Application Ref:	3/2025/0697			 Ribble Valley Borough Council www.ribblevalley.gov.uk
Date Inspected:	N/A	Site Notice:	N/A	
Officer:	LW			
DELEGATED ITEM FILE REPORT:				APPROVAL

Development Description:	Non-material amendment to application 3/2025/0114 involving a change of dormer wall material from wall hung concrete tiles to grey composite cladding.
Site Address/Location:	24 Kirkdale Road, Langho, BB6 8EW.

Rev	Date	Drawn by	Comments
Client			
Project			
24 KIRKDALE RD, LANGHO, BB6 8EW			
Drawing			
PROPOSED ELEVATIONS			
Date	Drawn by	Scales	
01 Oct 2025	###	1:100 @ A3	
Job No - Dwg No - Rev			
25007 - 04

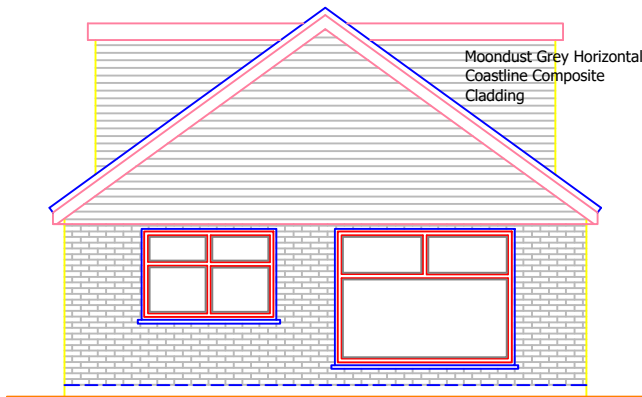
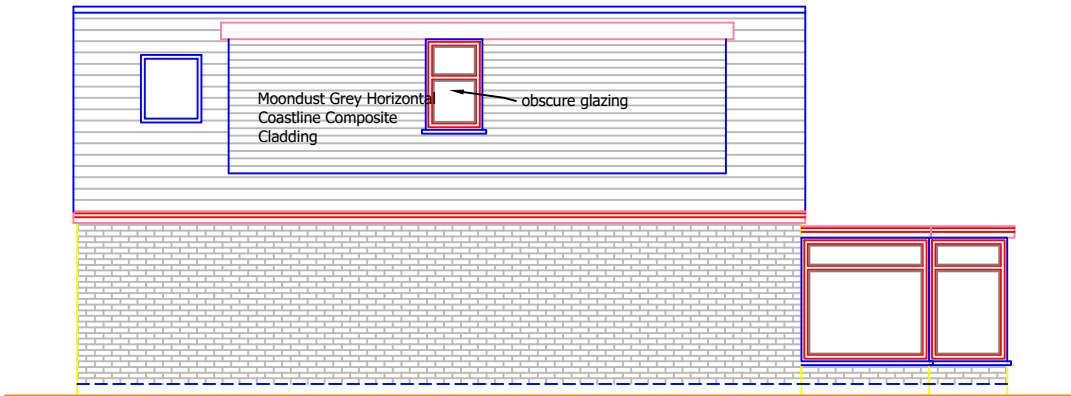
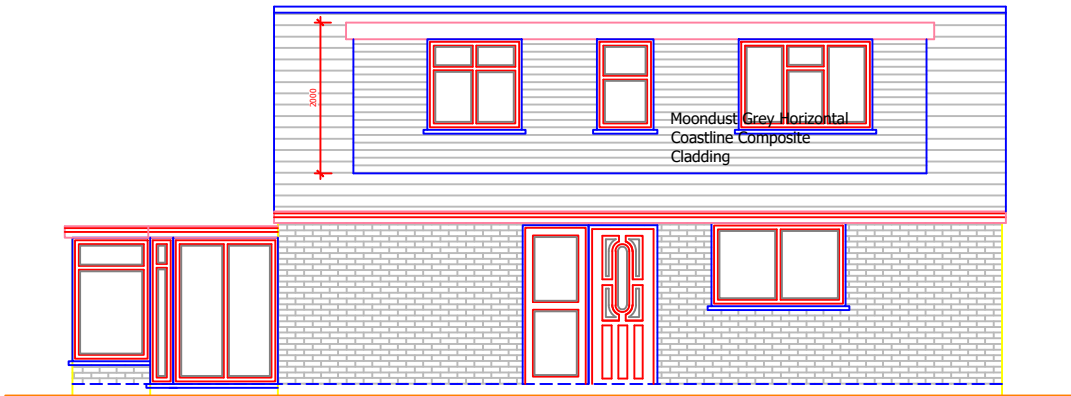
The amendments sought include an alteration to the previously approved external materials to the dormer extensions. Upon submission of the non-material amendment application, this included the replacement of the previously approved wall hung concrete tiles with black ash woodgrain shiplap cladding. However, the use of black cladding was not considered to appear in keeping with the external

facing materials featured along Kirkdale Road and therefore the proposal has been revised to instead include moondust grey horizontal coastline composite cladding. Whilst it is acknowledged that a darker grey cladding would better integrate with the roof of the main dwellinghouse, the proposed moondust grey cladding is, on balance, considered acceptable in this particular instance, insofar that the dormers are located to the sides of the dwellinghouse and would be read in context with the existing white cladding featured to the principal elevation of the property.

In this respect, it is not considered that the proposed amendment from wall hung concrete tiles to grey composite cladding would conflict with any of the Council's development management policies or conditions relating to the original planning permission granted, nor is it anticipated that the proposed amendment would exacerbate any concerns which were raised by any third parties at the original planning application stage. In this instance, the proposed amendments would therefore not amount to a development that is materially different, in terms of external appearance and impact on residential amenity, to that of the original consent and as such, it is considered that the proposed amendments would in this case be non-material.
